DEPARTMENT OF COMMUNITY DEVELOPMENT

July 25, 2005

RE: Vista View Estates Plat (P-05-03) - Plat Comments

VISTA VIEW ESTATES
PTN. SE 1/4, SEC. 1, T.17N., R.18E., W.M.
KITITTAS COUNTY, STATE OF WASHINGTON
DWN BY S.K./G.W. DATE 02/05 JOB NO. 04663
CHKD BY D.NELSON SCALE 1"=150' SHEET 1 of 3

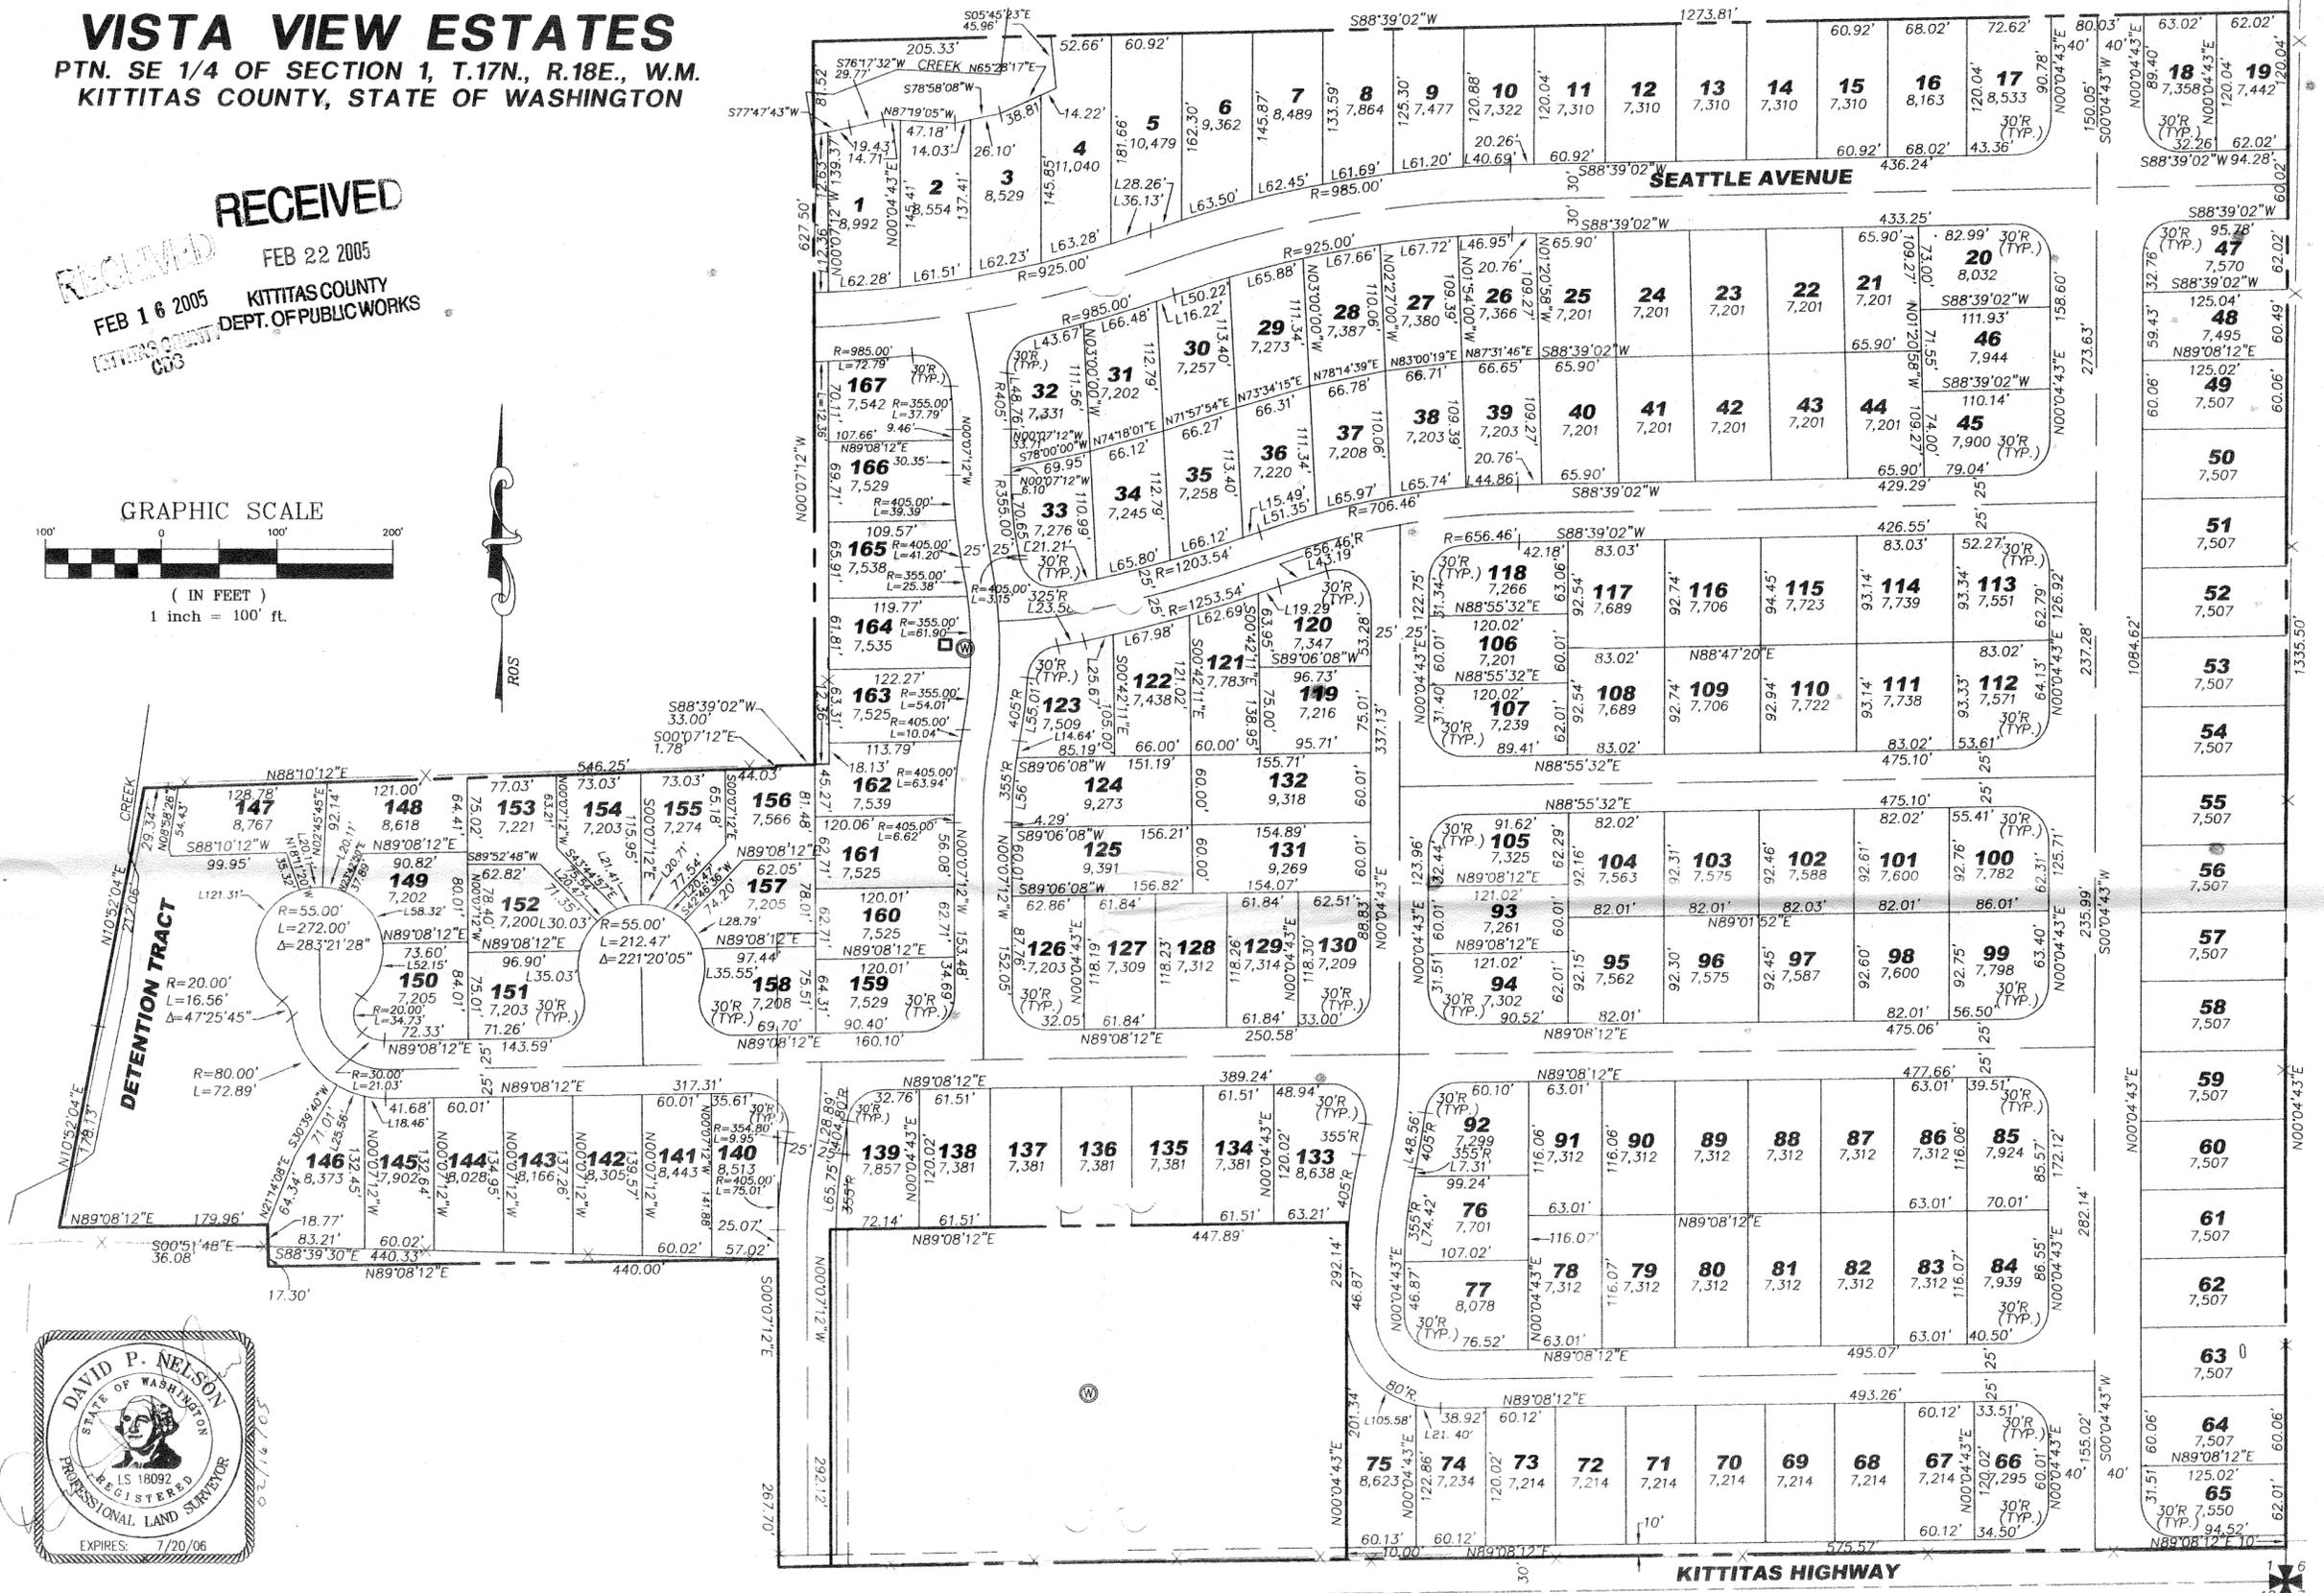
The Vista View Estates preliminary plat as proposed does not provide any north/south extension through the plat from Kittitas Highway and instead keeps all traffic entering from Kittitas Highway internal to the development except for a future option to extend Seattle Avenue to the west to connect with Willow Street. A more coordinated grid street system should be required for this plat and the SEPA MDNS that was issued July 11, 2005 has several requirements that the City is supportive of, including the requirements that:

The applicant will be required to work with the City to identify, plan and provide for a future north/south arterial/collector route between Kittitas Highway and Pfenning Road and to extend Seattle Avenue through the plat to connect to that north/south arterial/collector;

In addition to the Seattle Avenue right of way connection, a road right of way shall be stubbed out to the north boundary line for a future connection to Oak Street;

A future Locust Street, Seattle Avenue and Oak Street corridor shall be protected with a temporary cul-de-sac in order to accommodate for future extension;

The extension of Pfenning Road at the easterly border of the plat is also identified as a future arterial on the City's road master plan. The proposed Pfenning Road ROW shall be 80' wide; and,

The alignment of the proposed Pfenning Road will need to extend to the northerly edge of the proposed plat. Specific issues related to roadway alignment and driveway access will be reviewed at the time of civil plan submittal;
